MONUMENT WATERLINE & STORAGE TANK

MONUMENT, CO

FA PROJECT NO. 04-20-0153

MAY, 2022

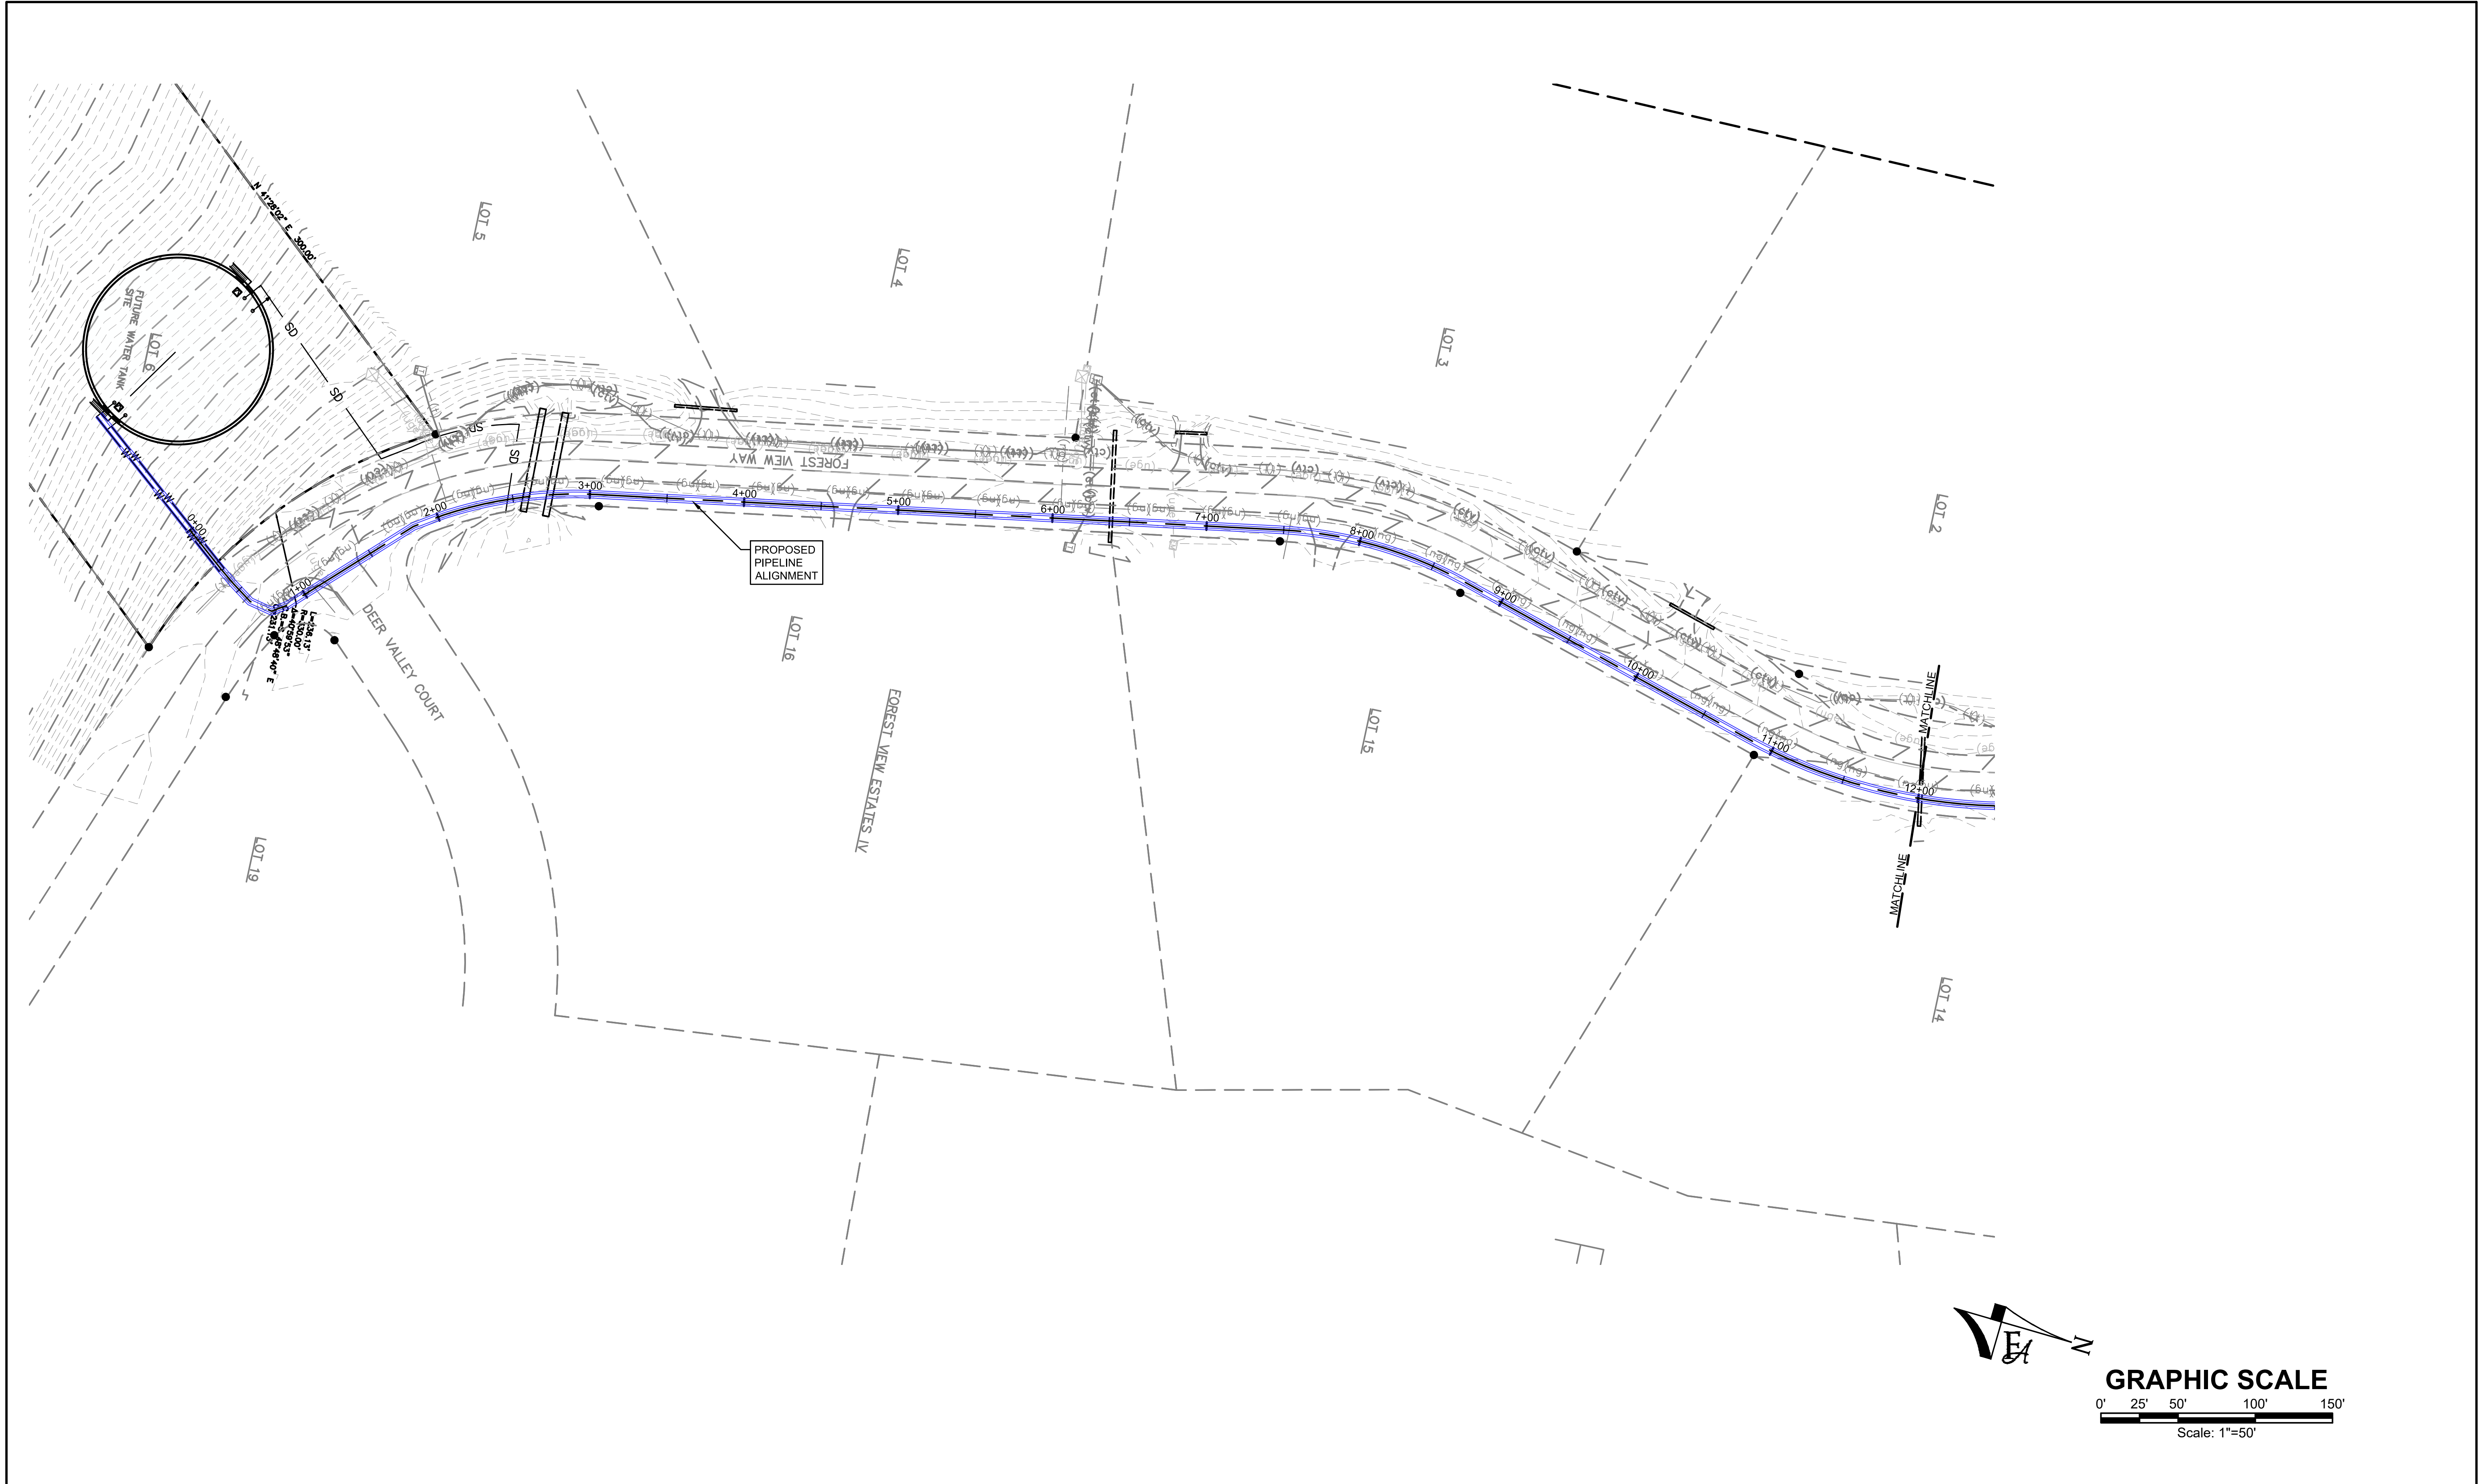
Please show thrust blocks in locations that will require them and make sure to show them in all plan sheets.

Per ECM SD. 4-2 waterlines shall have a minimum distance of 5' from other utilities. Please label all relevant utilities on plan view so that distance is easily measured. Make sure to do this on all plan sheets.
